# CITY OF ALBUQUERQUE

**RE: Independence Square (Jefferson/Osuna)  
Conceptual Grading and Drainage Plan and Drainage Report  
Engineer's Stamp Date 1-29-2016 (File: E17D076)**

Based upon the information provided in your submittal received 1-29-2016, the above-referenced plan is approved conceptually for Site Plan for Subdivision. The following comments, however, will need to be addressed prior to approval for platting action (we understand DRB will upgrade the Minor PP/FP to a Major PP/FP):

ENGINEER'S SEAL	6701 JEFFERSON ST ALBUQUERQUE, NM	DRAWN BY pm
	GRADING AND DRAINAGE PLAN	DATE 2-15-16
		DRAWING 2014065-GR
	 TERRA WEST, LLC 5571 MIDWAY PARK PL NE ALBUQUERQUE, NEW MEXICO 87109 (505) 858-3100 www.tierrowestllc.com	SHEET # GR-1
VINCENT P CARRICA P.E. #16212		JOB # 2014065

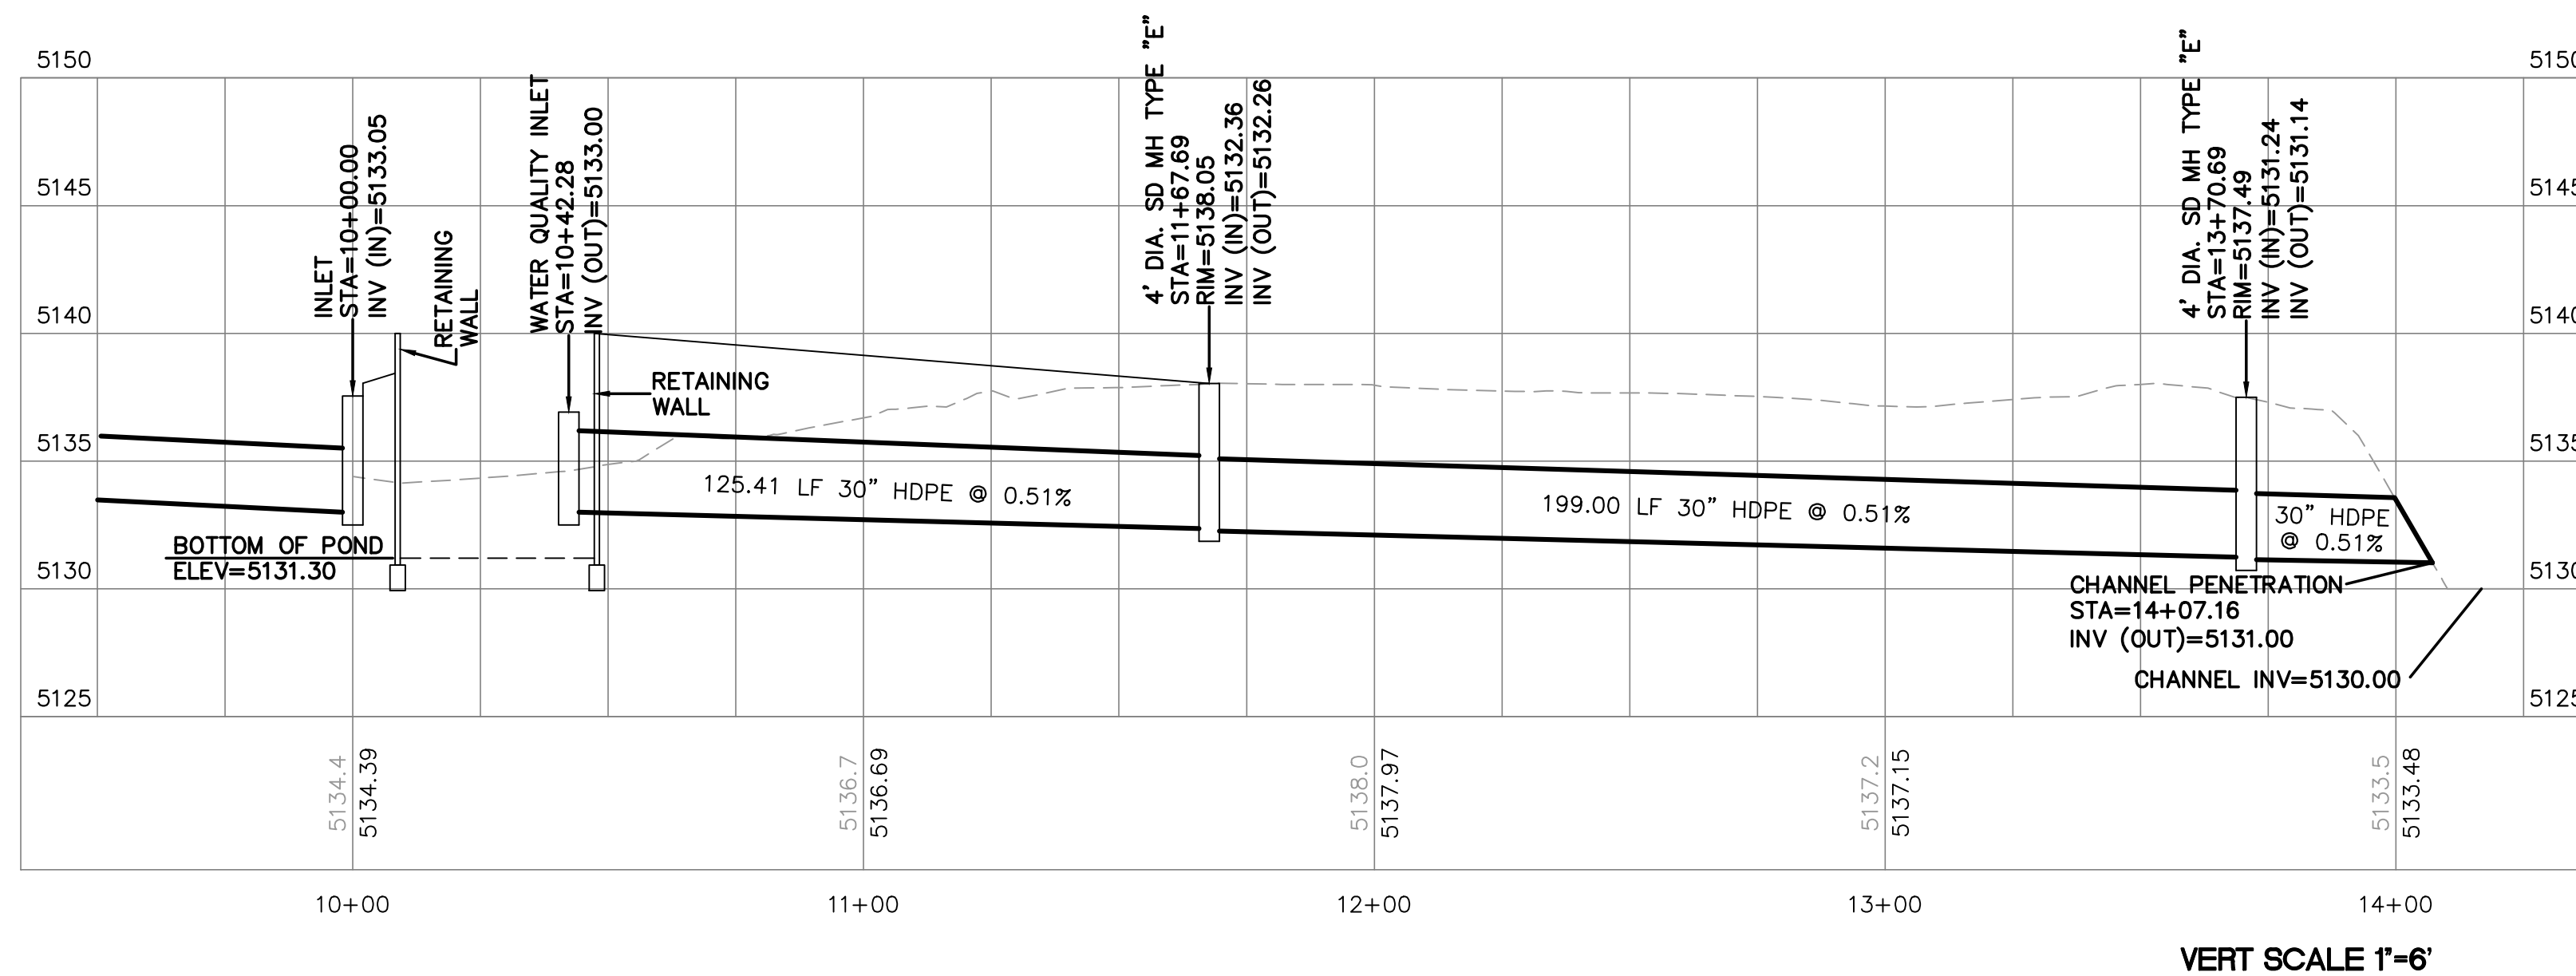
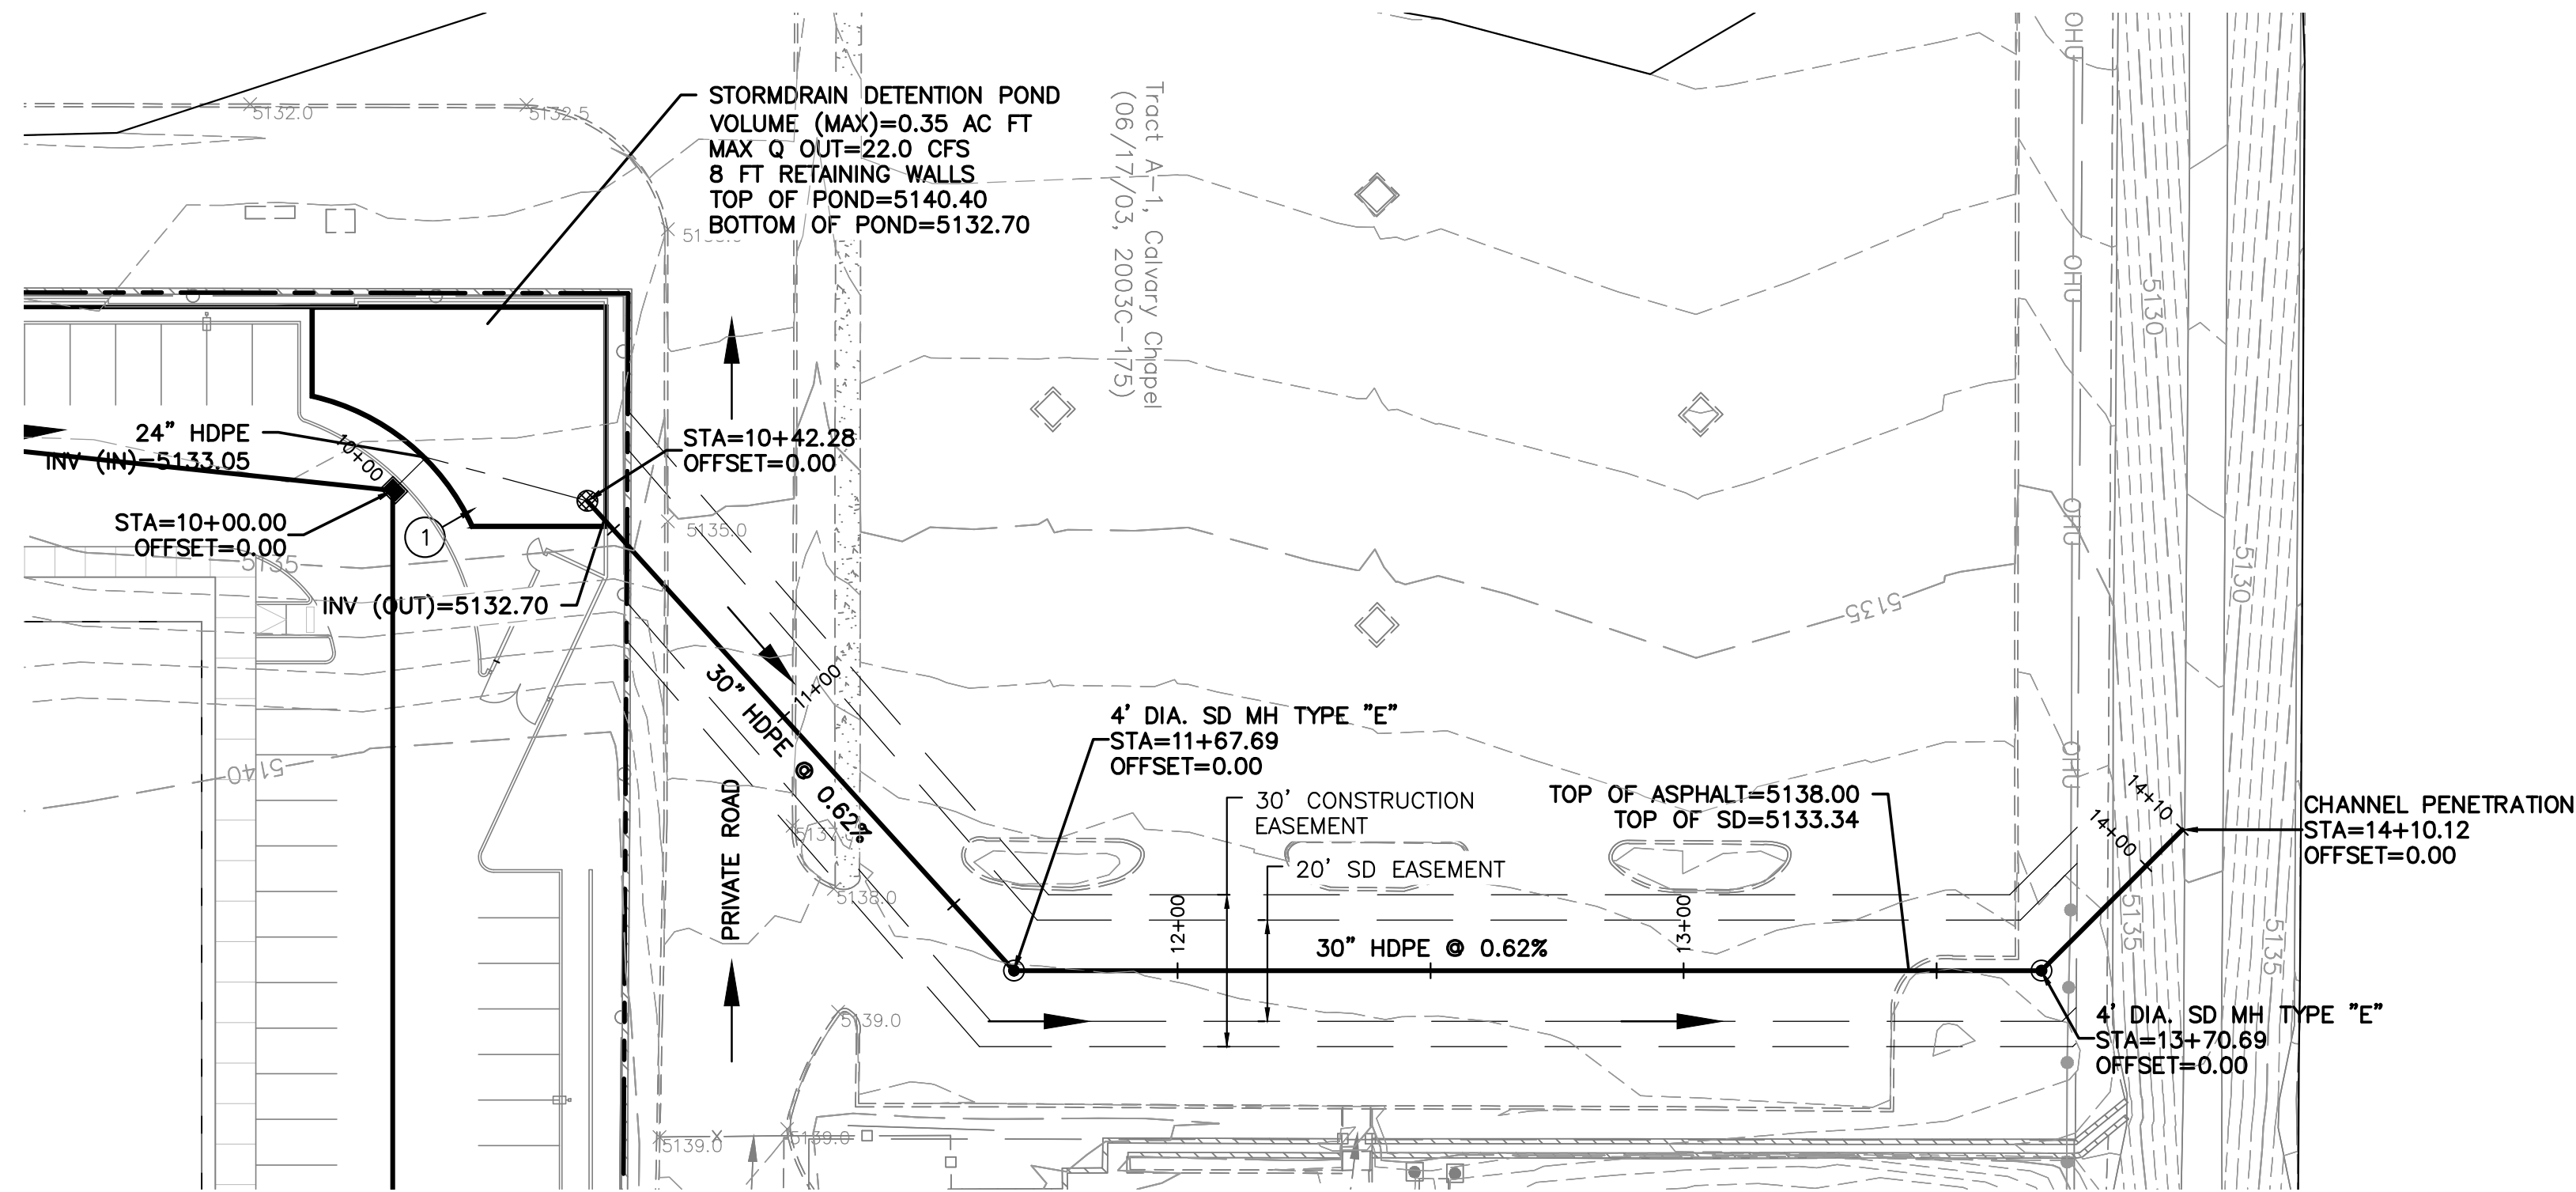
1. The Drainage Plan anticipates conveying flows through storm drain lines across lot lines to the detention pond on Lot 4. These facilities will need private drainage easements. It is also unclear if surface drainage easements are needed over the access easements as well, (basin limits are not at the lot lines).
2. Clarify the outlet of the detention pond. It appears that the masterplan of the existing church site anticipates accepting offsite flows as described in the Report. However, is the landscaping strip designed to accept a point discharge from this site?

1. The first flush volume required calculation appears to be low (5.99 acres impervious times 0.34"  $\approx$  7392 CF). Clarify the amount of first flush that volume will be needed to be retained on each lot; the report mentions that a portion of the volume will be retained on site, and the rest in the detention pond.
2. As mentioned above, the detention pond will need to be detailed and analyzed to show how it decreases the peak discharge as stated in the Report.
